Planning Application: Seeking advice on an **OUTLINE** planning application for this site for 157 new dwellings.

Reference: **WA/73/17/OUT**

Location: **Land east of Wandleys Lane and west of West Walberton Lane, Fontwell**

Key:

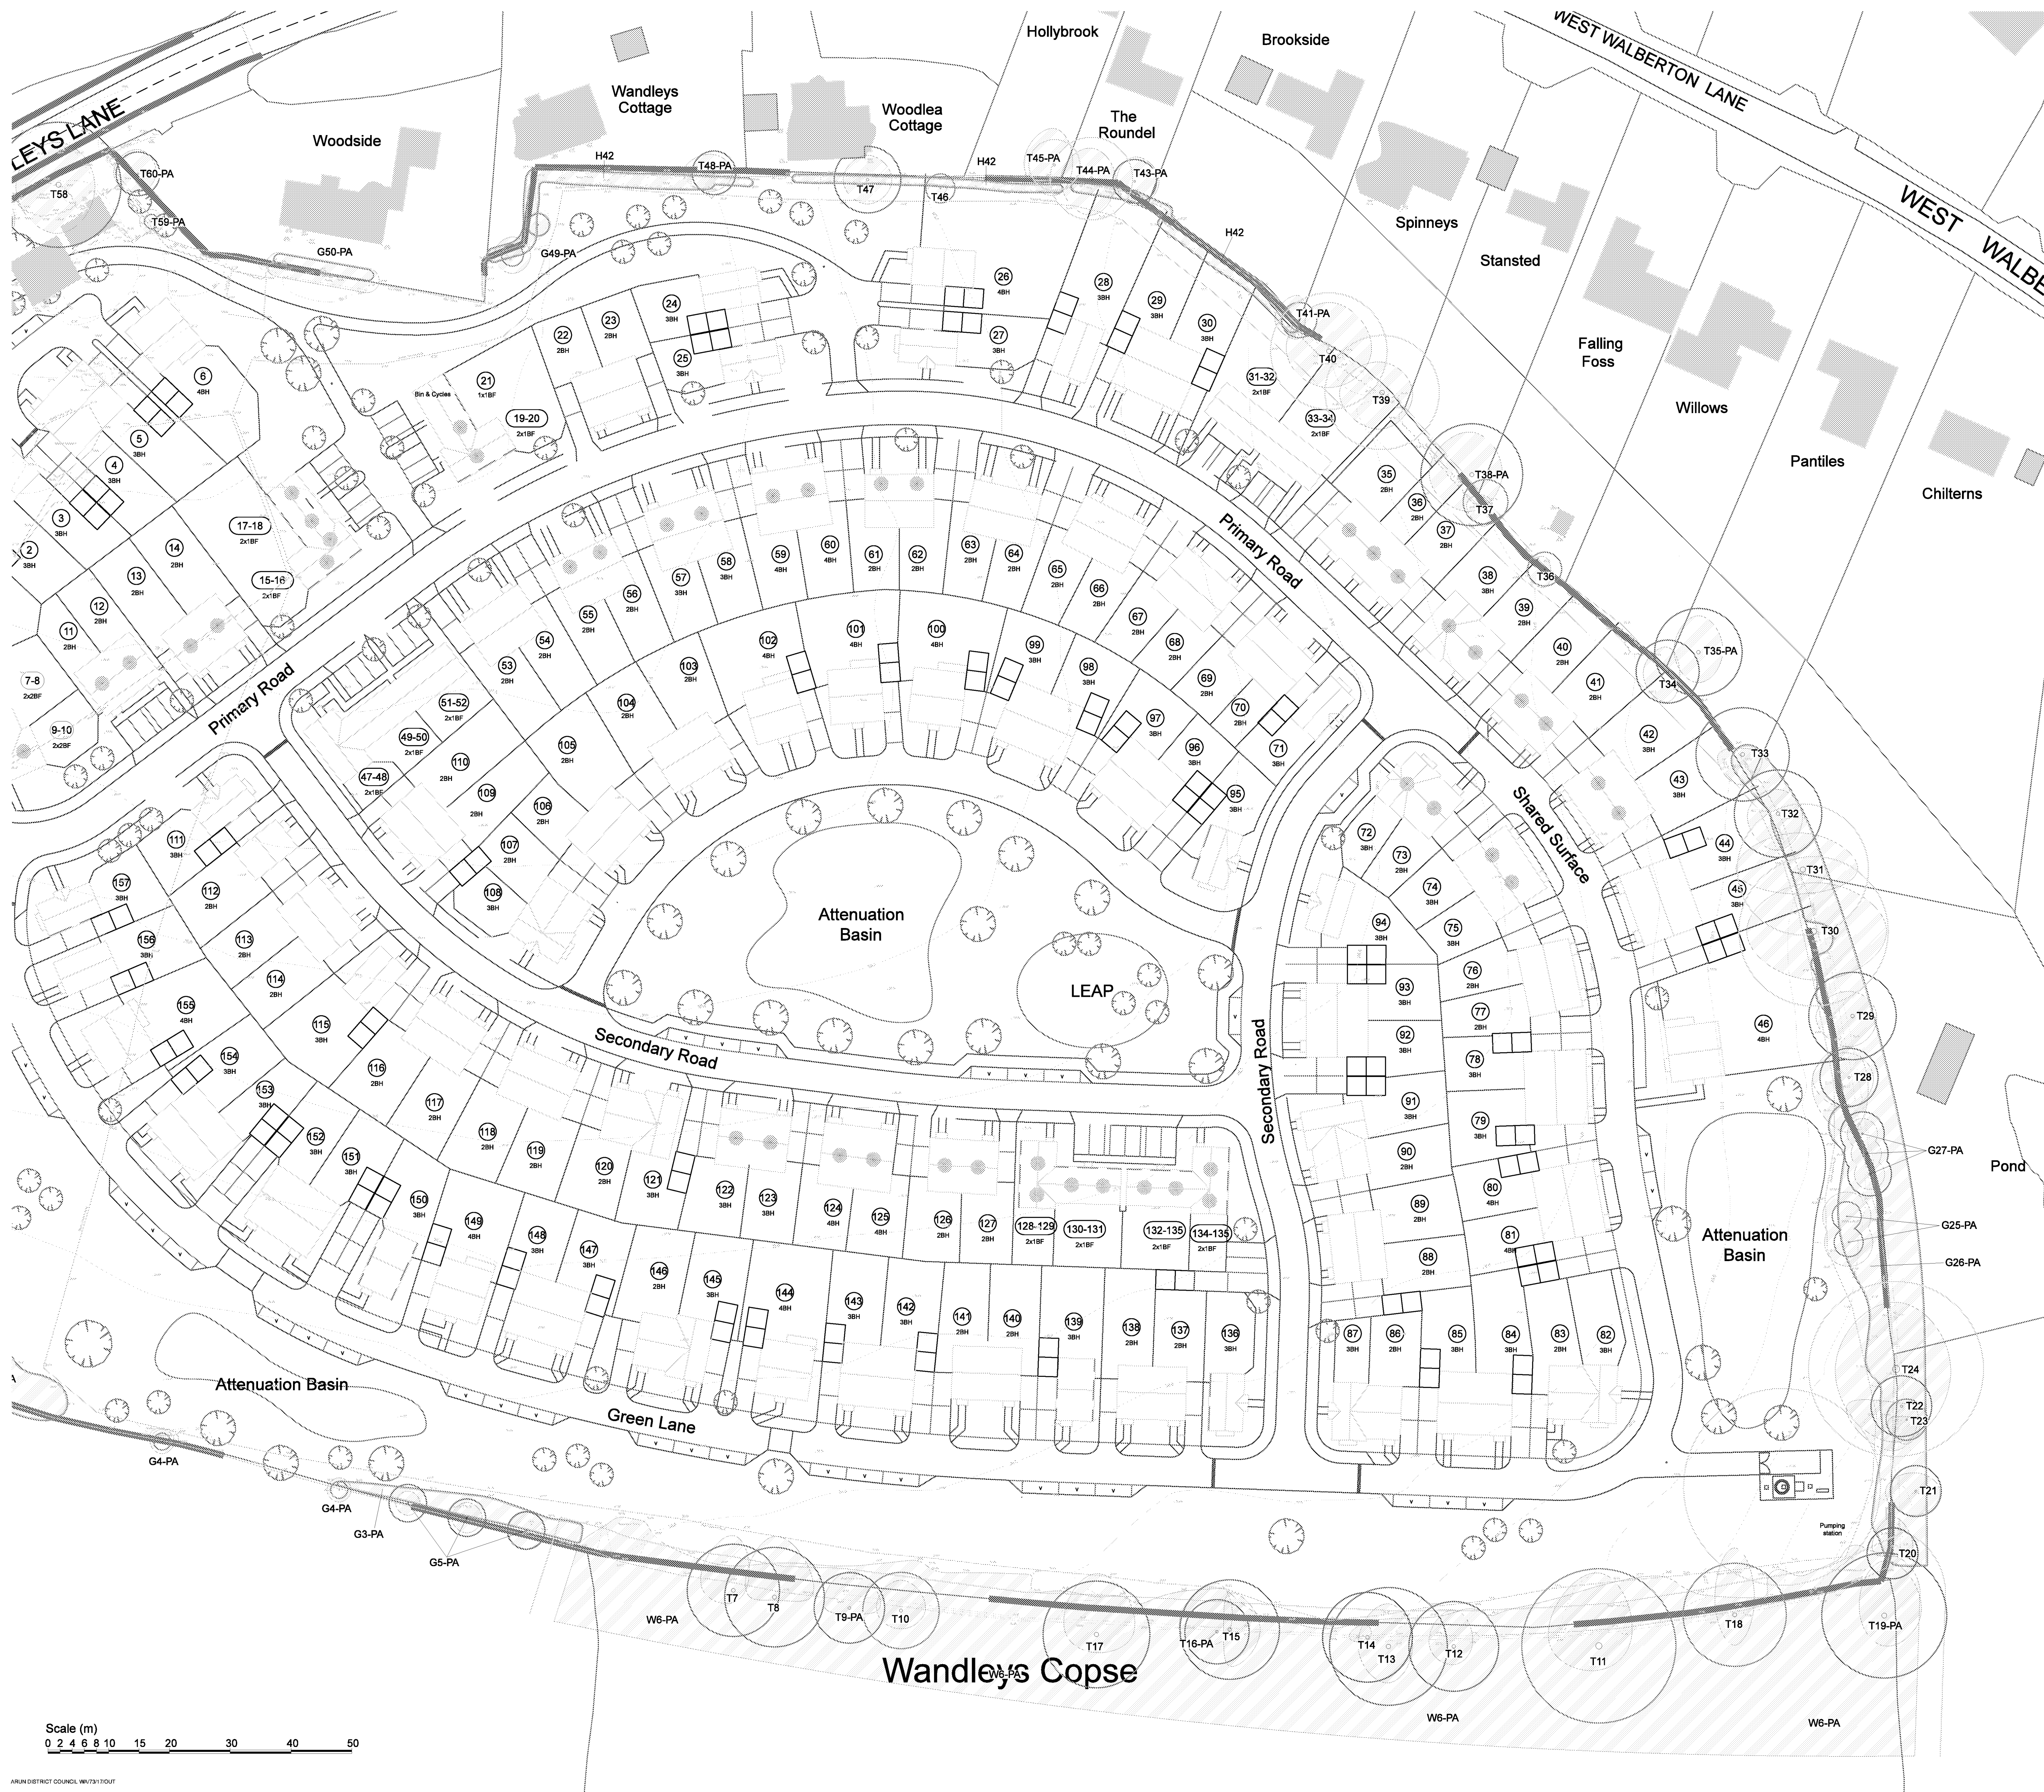
- This has highlighted that there will be some issues to resolve with regards to the access points and new footpath links because they overlap retained tree RPA's.

- They have also submitted an Arboricultural Method Statement report & Tree Protection Plan which 'jumps the gun' as there is no way of knowing whether this will be the final layout that comes in at the detailed planning application stage!

- The accuracy of the tree survey and root protection data submitted in support of this outline application is acceptable.
- The AMS & Tree Protection Plan will need to be revised and annotated to cater for the items mentioned above.

- Whilst I find that the base data submitted in support of this outline application is acceptable the level of information provided in the AMS and on the Tree Protection Plan is not detailed enough and requires more attention when this application comes back in seeking a full and detailed approval.
- However, overall in arboricultural terms I am comfortable with their proposals and would be happy to see it go through to the Detailed Application stage.
